Memorandum

To:	Norine Allerdice	Date:	October 27, 2022
From:	April Ng		
Project:	Butenwieser/Wiley Residence 6838 96 th Ave SE Mercer Island, WA 98040 King County APN 302405-9010	File No:	2205-199
Subject:	Building Permit Review 1 Response

The comments are restated below, followed by responses. Updated drawings have been clouded with Revision 1: 10/27/22 Building Permit Resubmittal.

GARAGE AND SHED PLANS
S151

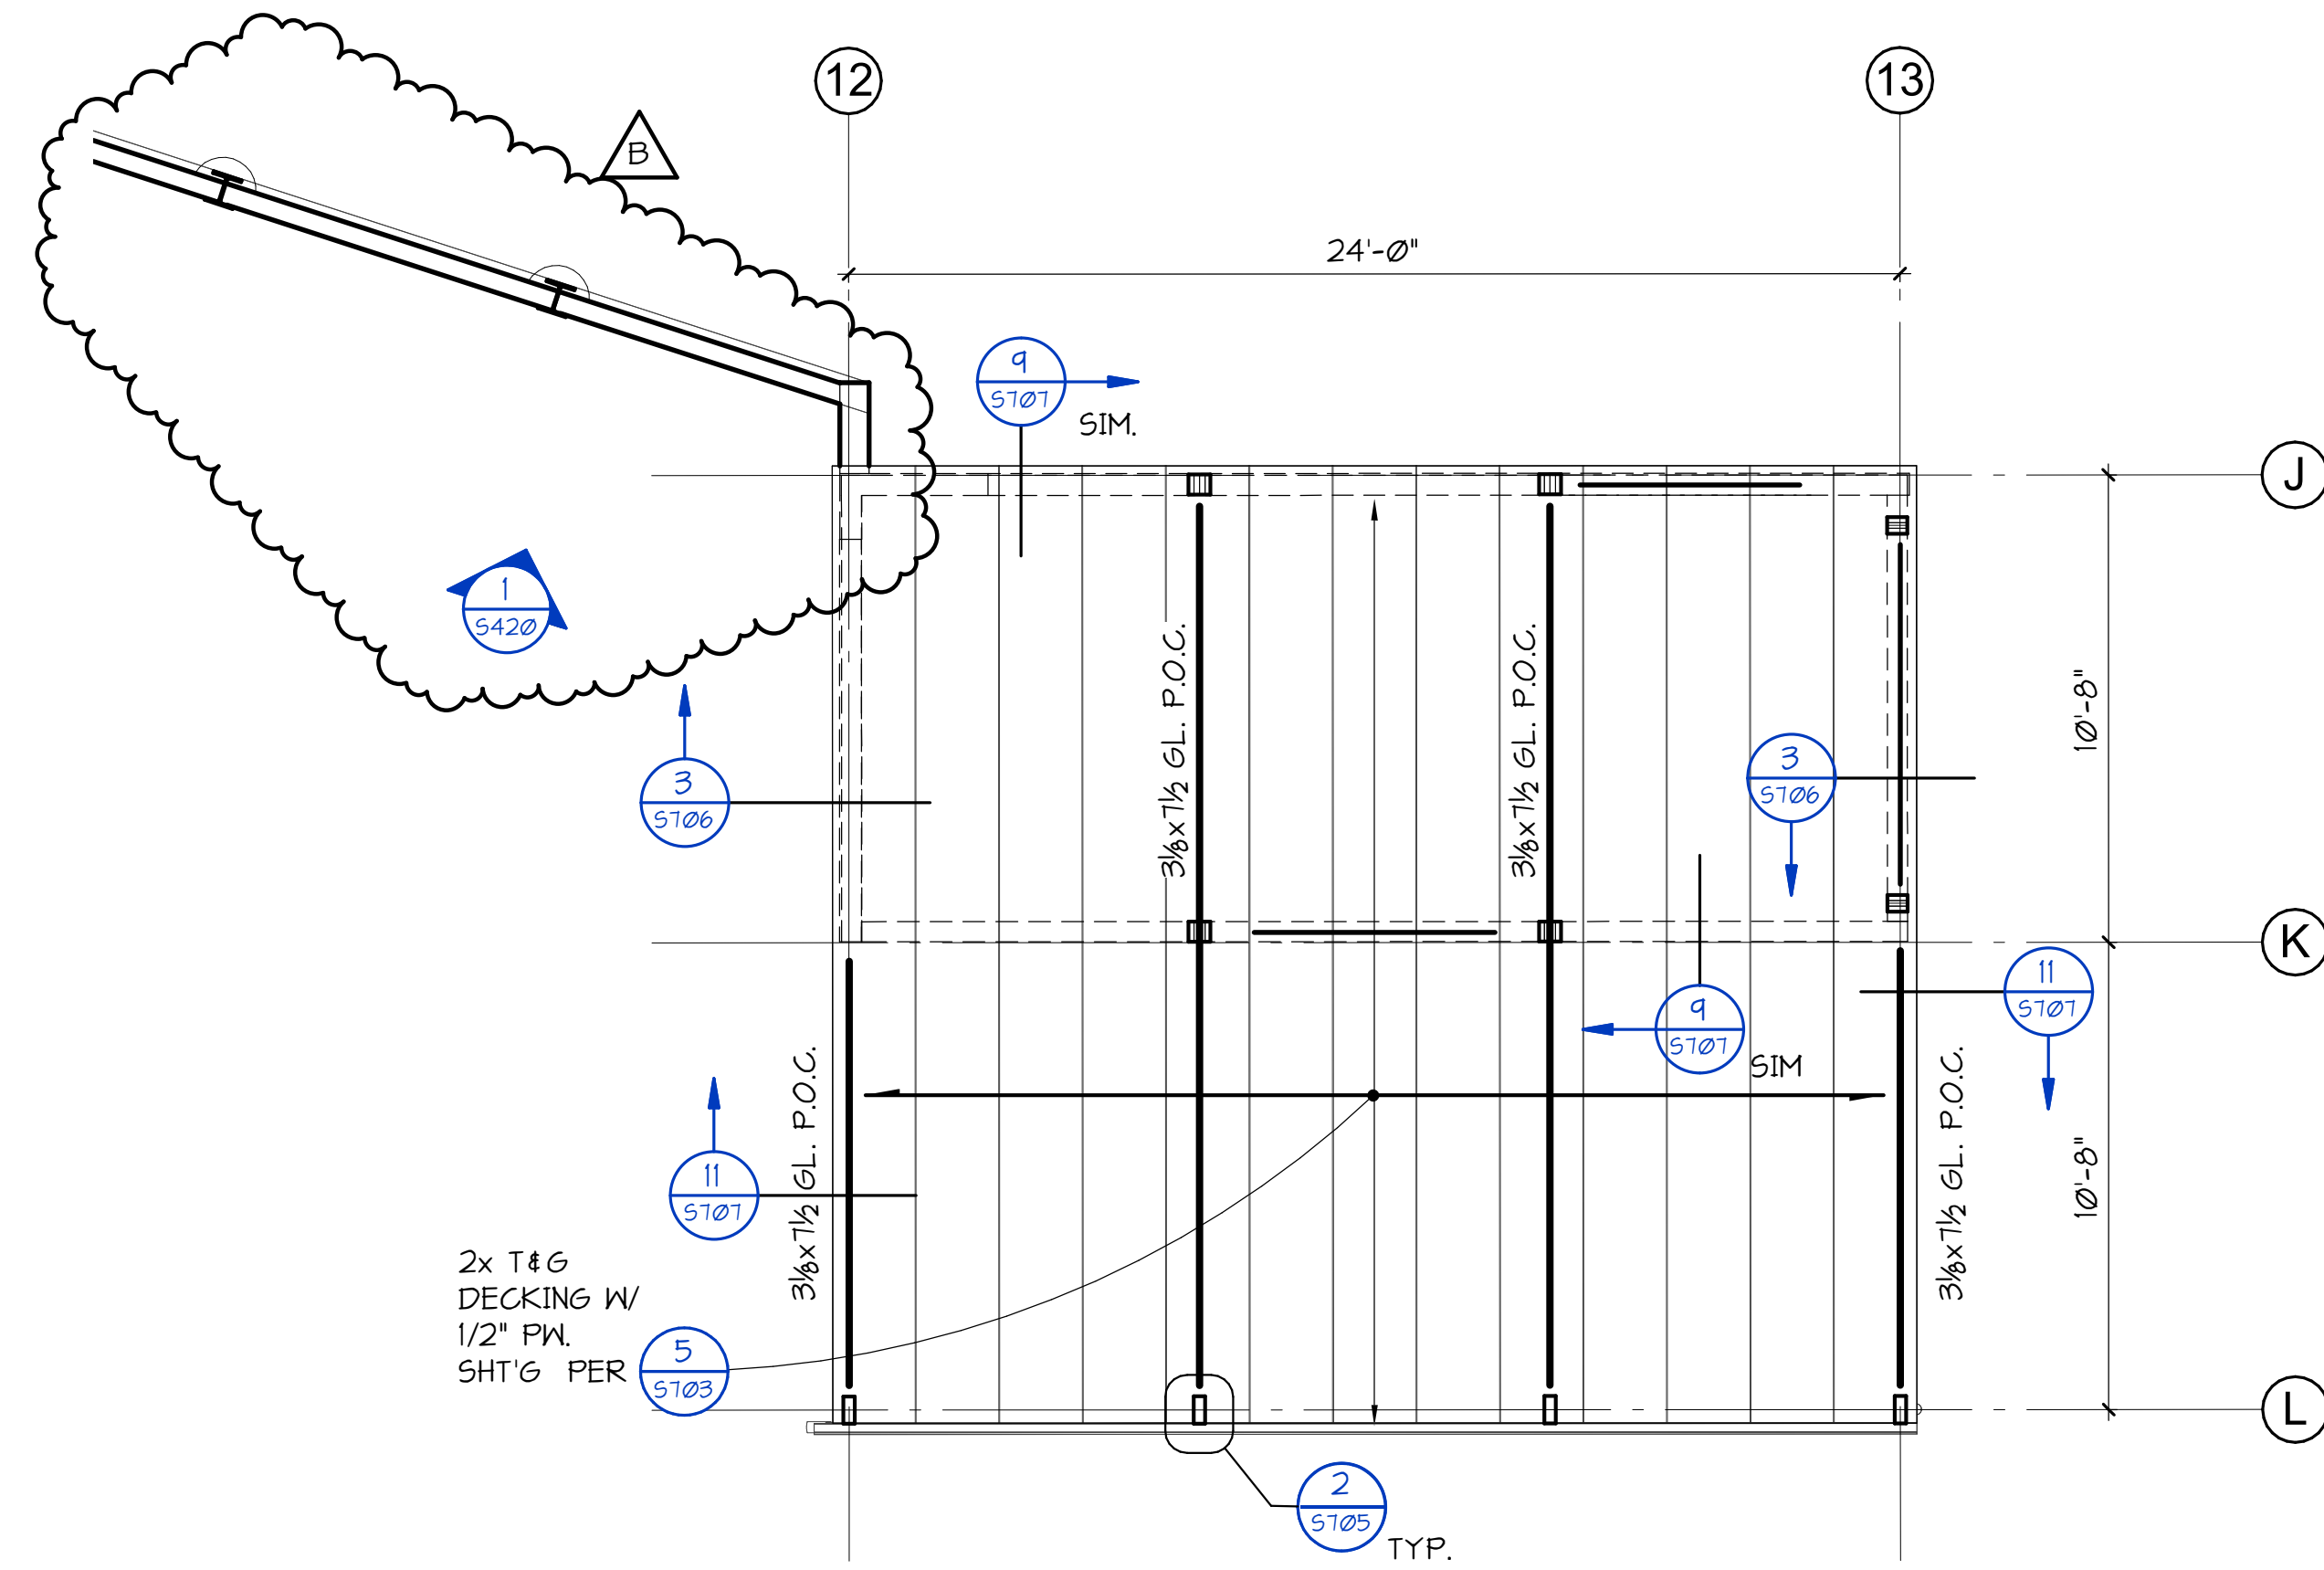
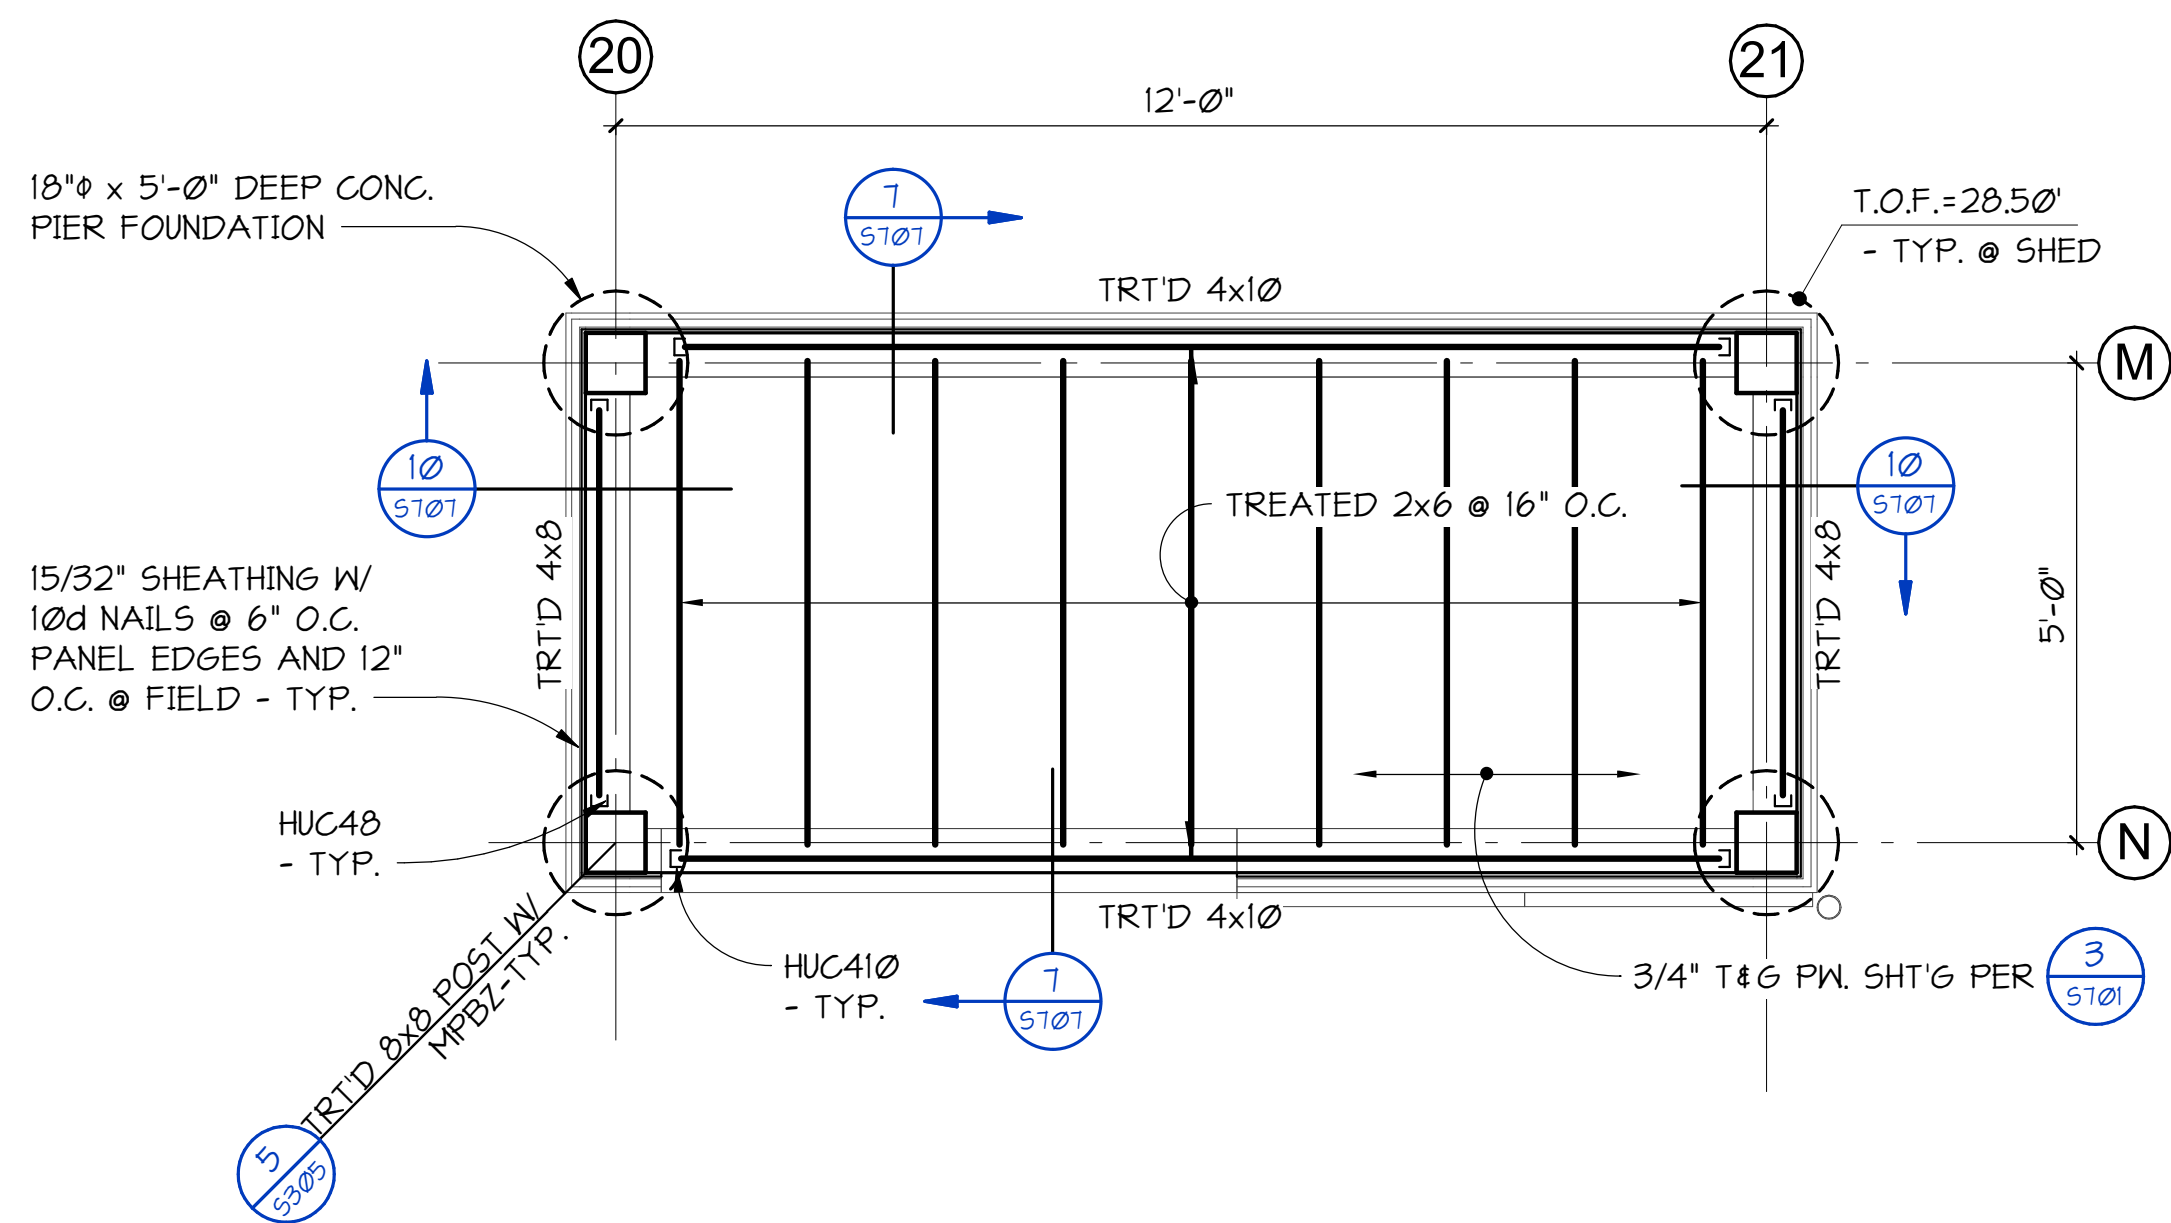
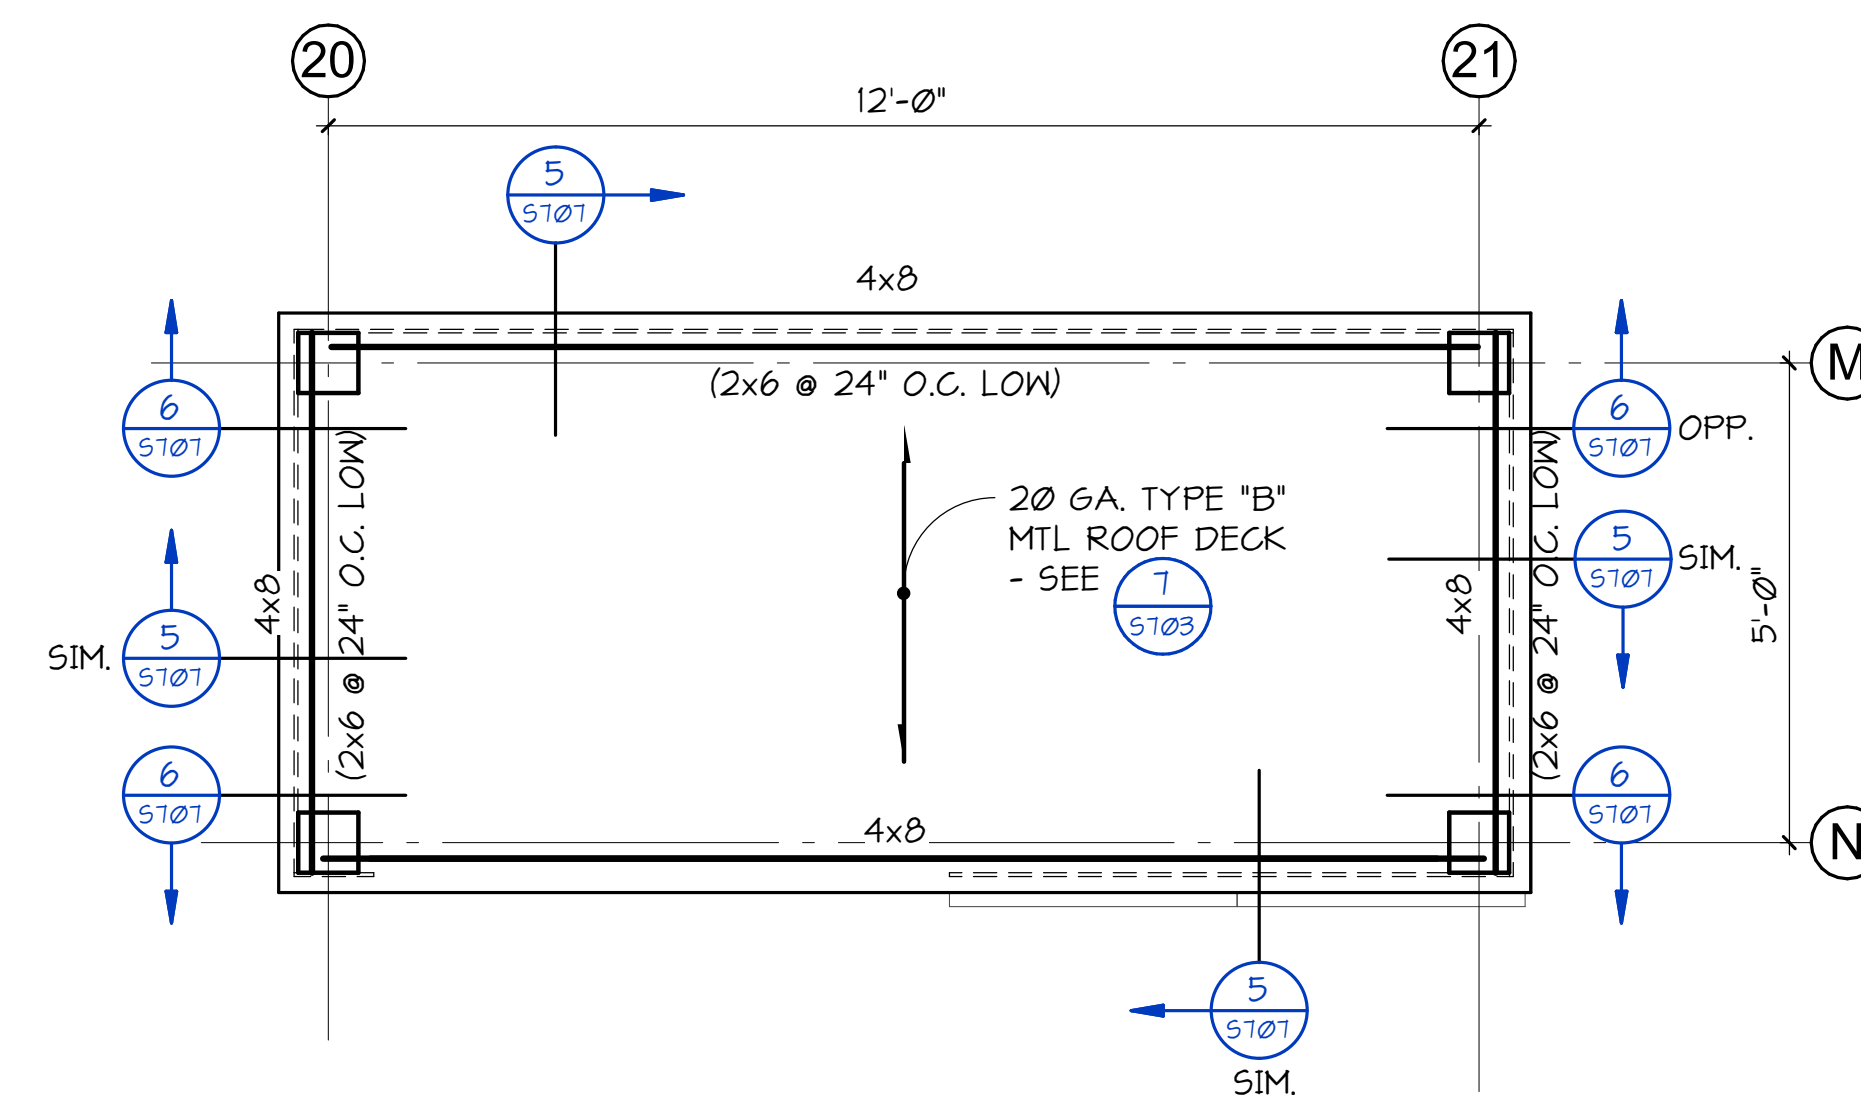
Tree Review		
<i>Comment</i>	<i>Response</i>	<i>Document Ref.</i>
C200B	A shed that is above grade on piers is proposed to replace the existing shed. Grading in this area is proposed to be	C101A, C101B
